CITY OF ALBUQUERQUE

July 19, 2018

Re: route 66 Plaza, 8521 Central Ave NE
Request for Certificate of Occupancy
Transportation Development Final Inspection
Engineer's/Architect's Stamp dated 05-17-16 (K19-D043)
Certification dated 06-14-18

SHEET NUMBER
AS-1.0

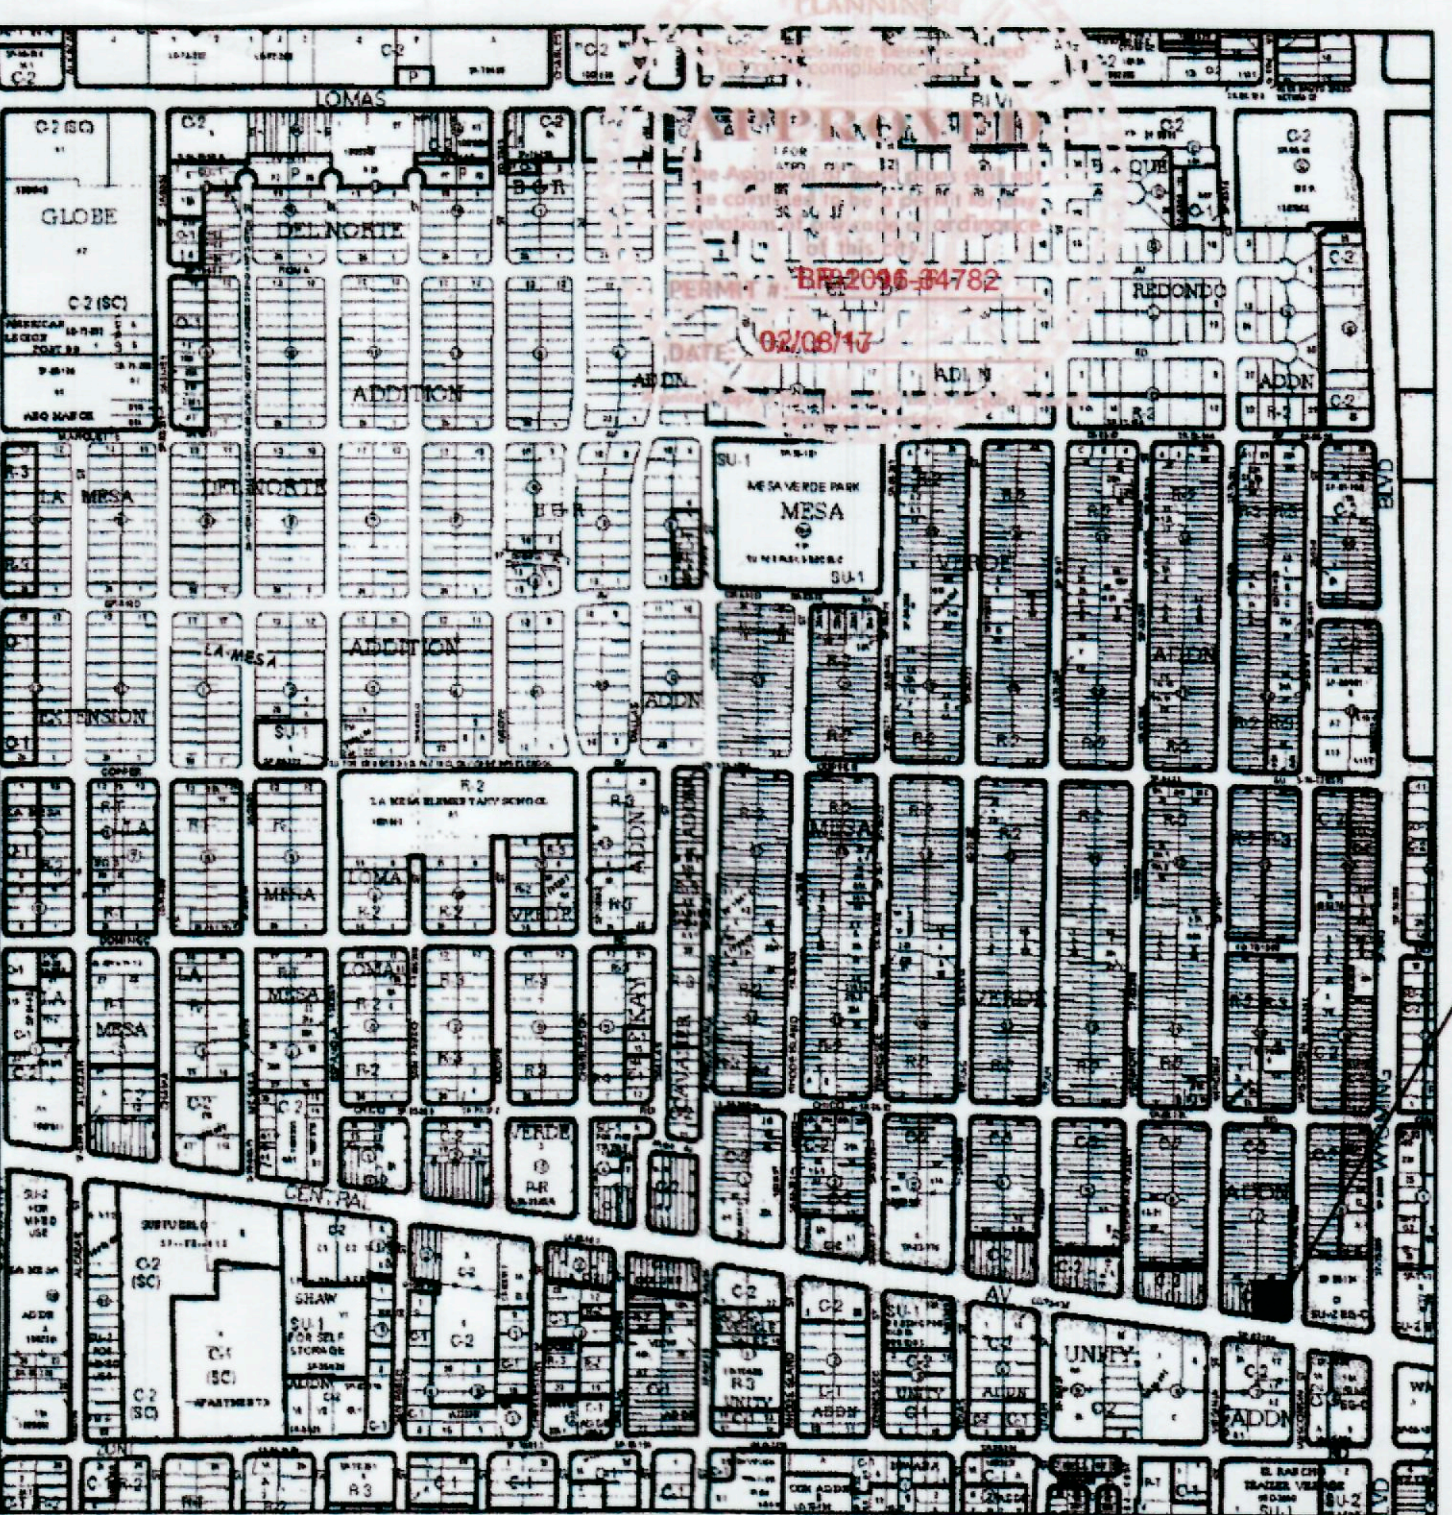
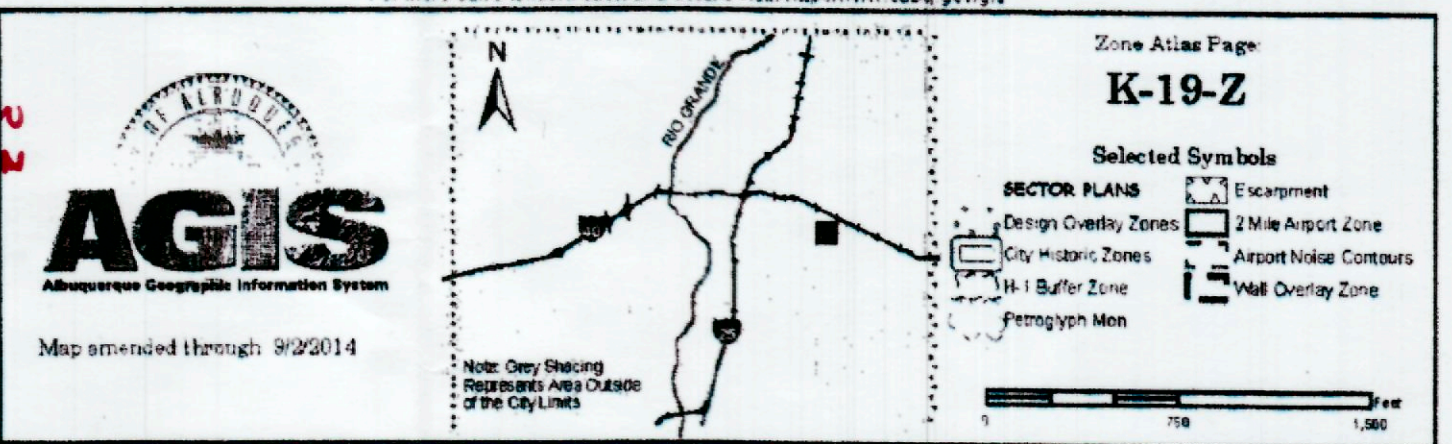
- The drive-up-window will not be allowed at this site. The drive through cannot be located adjacent to a fire lane, fire connect, or building egress/ingress. The site does not have enough room for car stacking.
- All unused curb cut and driveways must be closed with curb & gutter and sidewalk. City of Albuquerque standard drawing 2415A and 2430.
- The ADA accessible parking sign must have the required language per 66-7-352.4C NMSA 1978 **"Violators Are Subject to a Fine and/or Towing."**
- The ADA access aisles shall have the words **"NO PARKING"** in capital letters, each of which shall be at least one foot high and at least two inches wide, placed at the rear of the parking space so as to be close to where an adjacent vehicle's rear tire would be placed. (66-1-4.1.B NMSA 1978)
